Project Name: NZ COMMERCIAL OFFICE CENTER

**CITY OF ALBUQUERQUE
PLANNING DEPARTMENT
September 18, 2013
DRB Comments**

RE: Lot 12-A, NZ Commercial Office Center

TOPO MAP OF
 LOTS 12-A-1 AND 12-A-2
 NZ COMMERCIAL -
 OFFICE CENTER

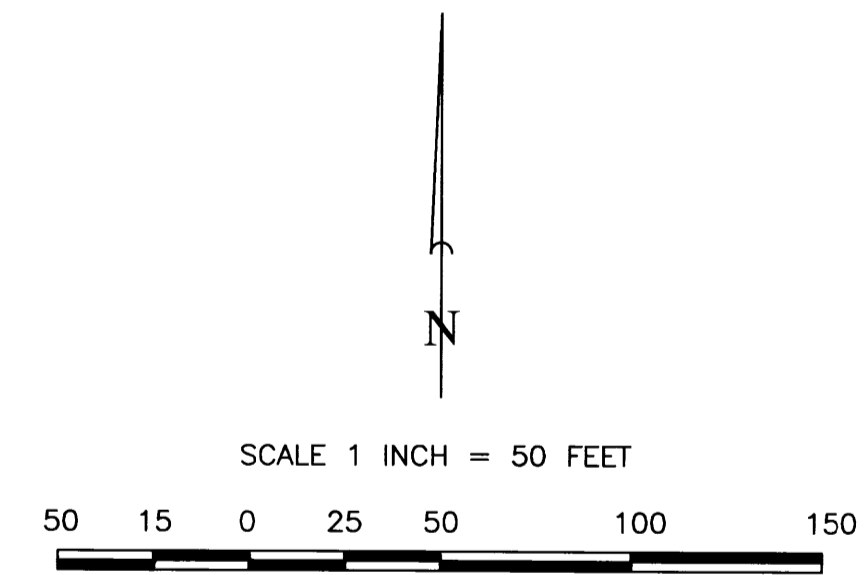
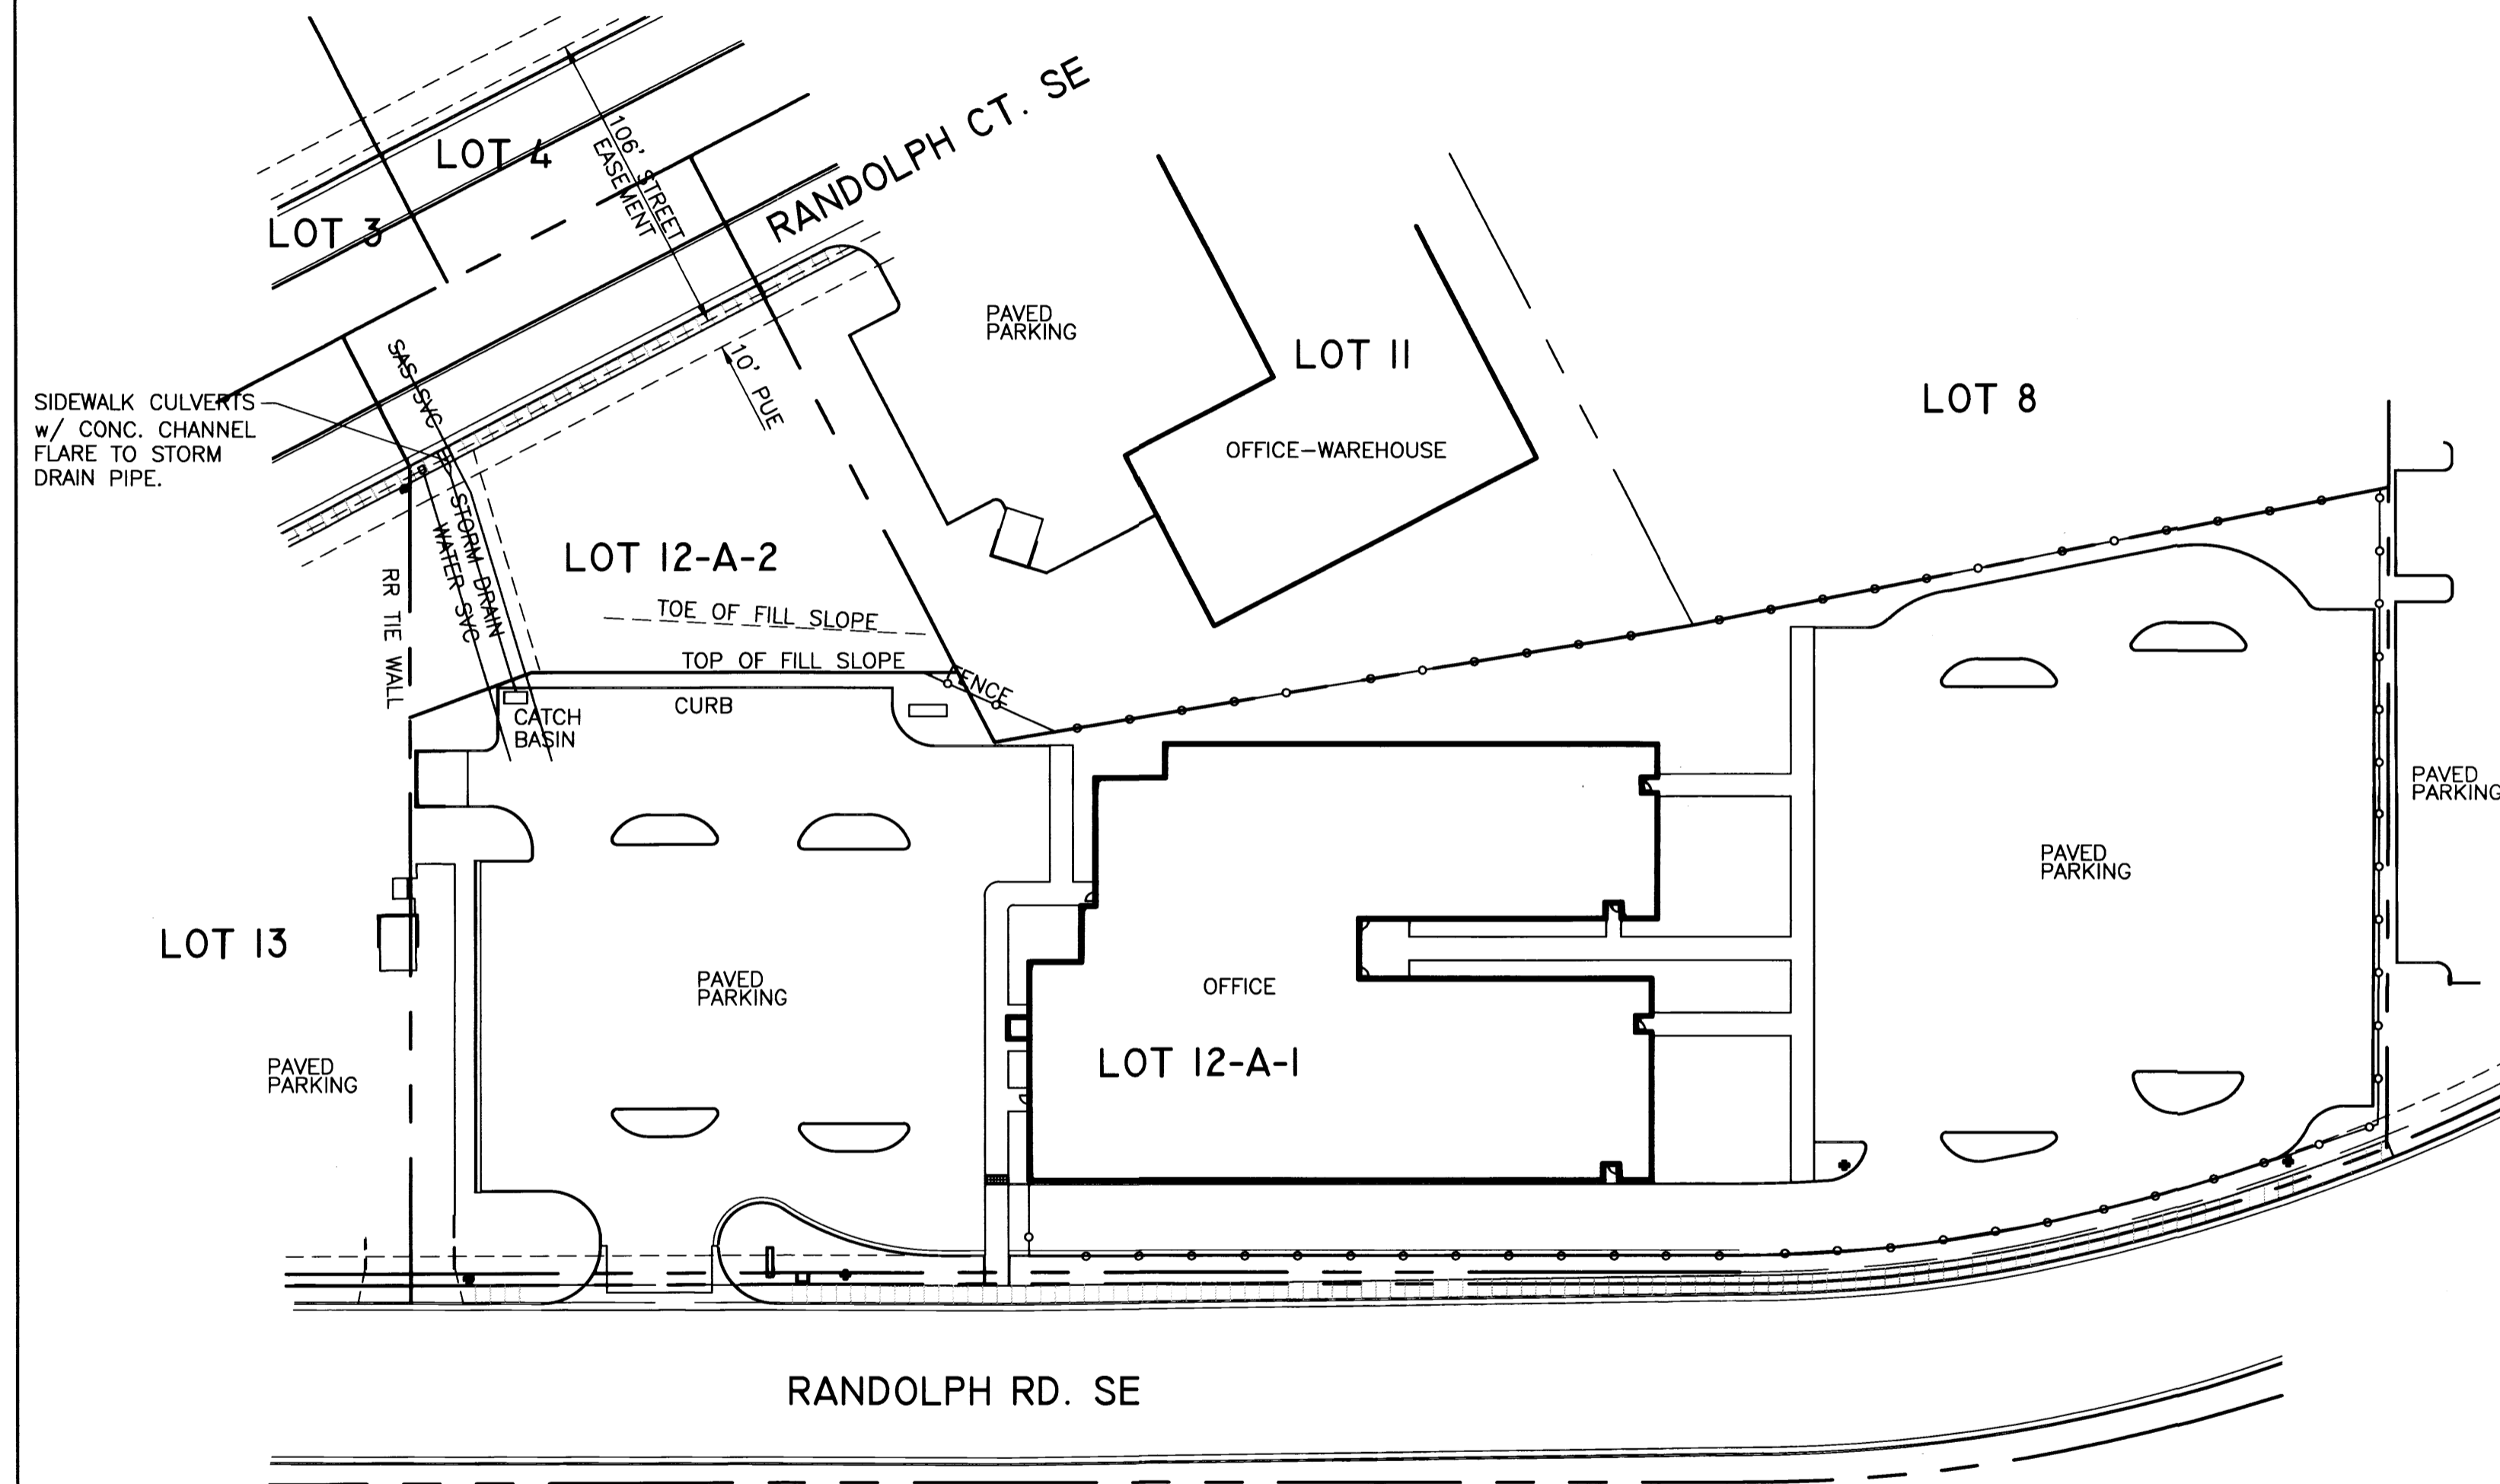
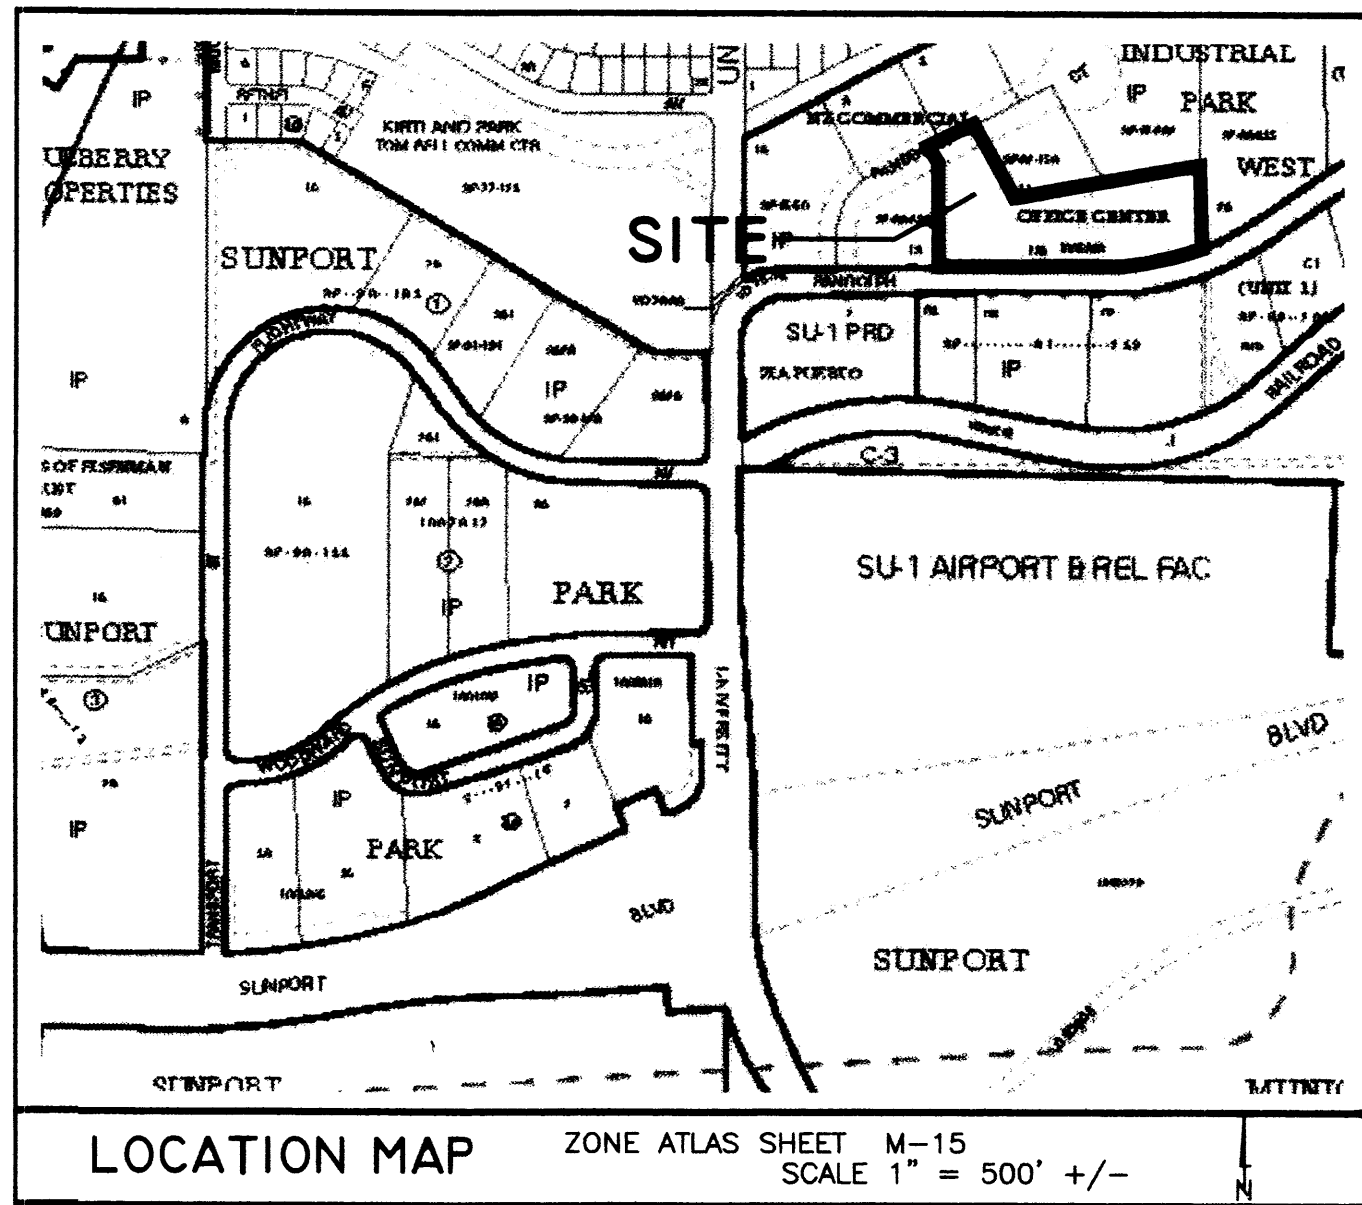
TRANSPORTATION: provide dimensioned exhibit

PLANNING (Last to sign): red, white sigatures
verify 5-ft rear landscape buffer

A more detailed exhibit is needed to demonstrate compliance with the required 6 foot rear landscape buffer per the Zoning Code; the submitted Topo Map scales at 5 feet, so an additional one foot landscape easement may be needed (or a variance to the rear landscape buffer). Additionally, the approved site plan for 1005390 needs to be amended as it shows further landscaping improvements into proposed new lot.
